Application for a non-material amendment following a grant of planning permission.

<input type="text" value="Erection of single / two storey extension to include rear juliet balcony and changes to fenestration."/>	
Reference number:	<input type="text" value="3/19/0727/HH"/>
Date of decision	<input type="text" value="10/06/2019"/>

1. Omit juliet balcony and replace with a standard window of the same overall width.
2. Replace sloping roof to proposed en suite shower room with a flat roof.

drawing no: 18604/21/02.

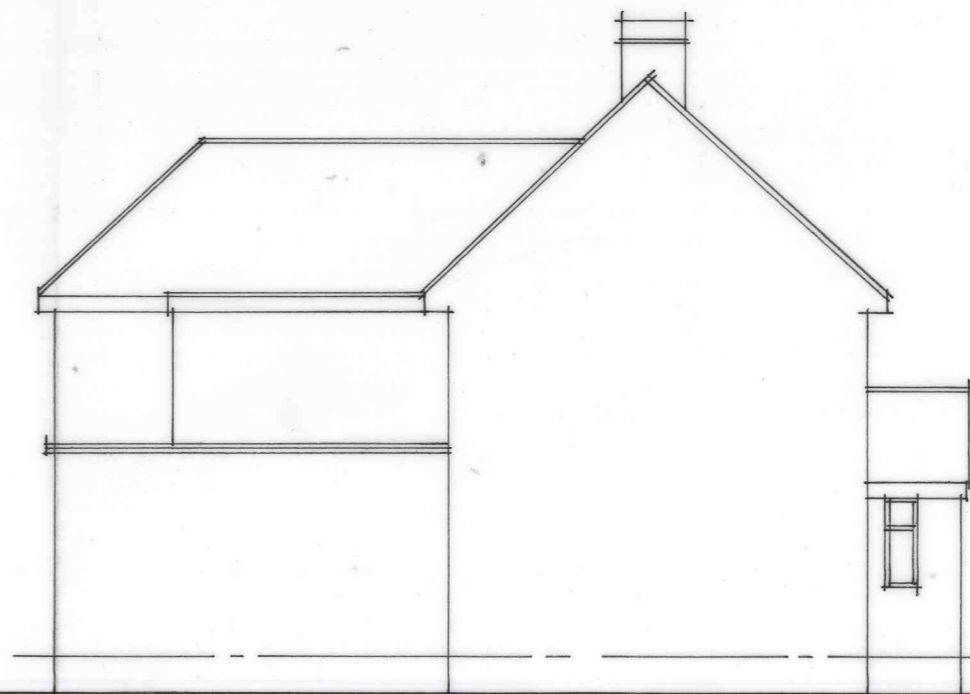
1. Juliet balcony to be replaced by a standard window because of a cost issue with the proposed balustrade.
2. The roof to be amended over the shower room as the height within the proposed extension will not be sufficient to enable the sanitary fittings to be installed and used.
